Application by Thurrock Power Limited for an Order Granting Development Consent for the Thurrock Flexible Generation Plant project.

The Examining Authority's Written Questions and Requests for Information (ExQ1)

Issued on 16 February 2021

Figure 1.1: Development zones.

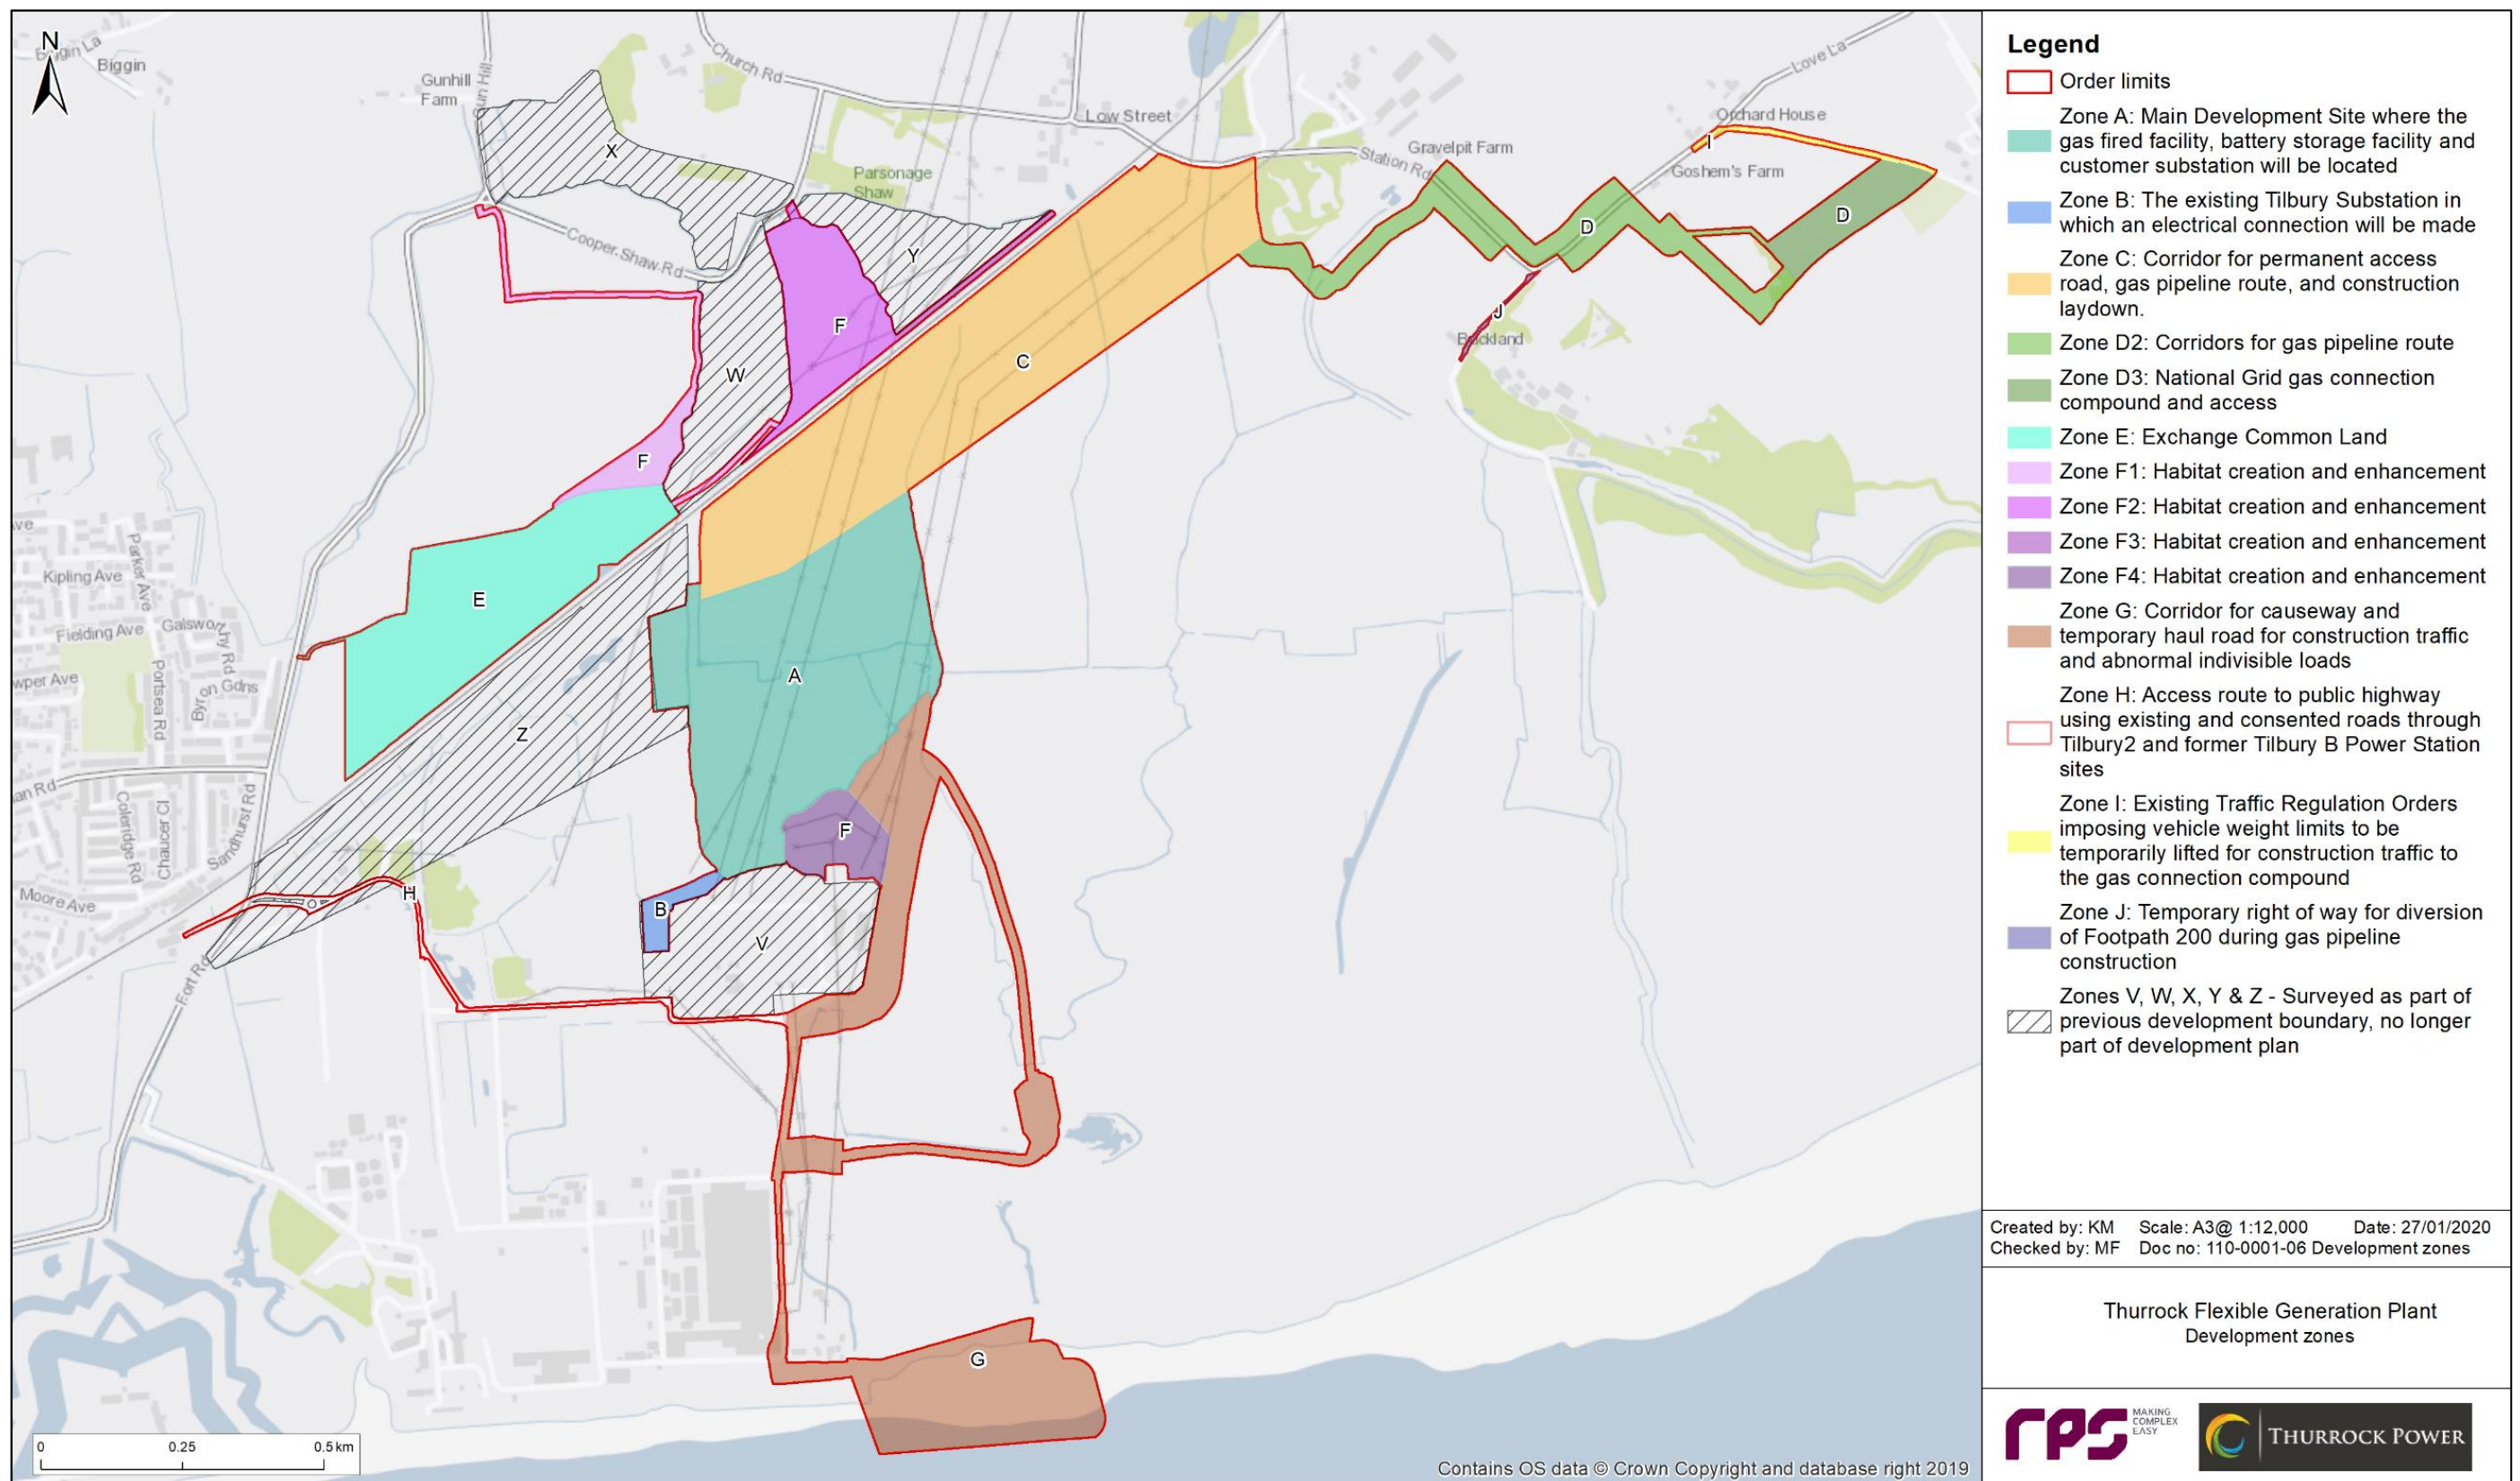
1.1.2	Applicant	Paragraph 4.1.16 of ES Chapter 12 states that receptors have been included at distances within 20m, 50m, 100m, 200m and 350m of the site boundary (excluding Zone E). However, Figure 4.1 shows that other Zones have been excluded. Please confirm the study area used and provide justification for any other development zones excluded.
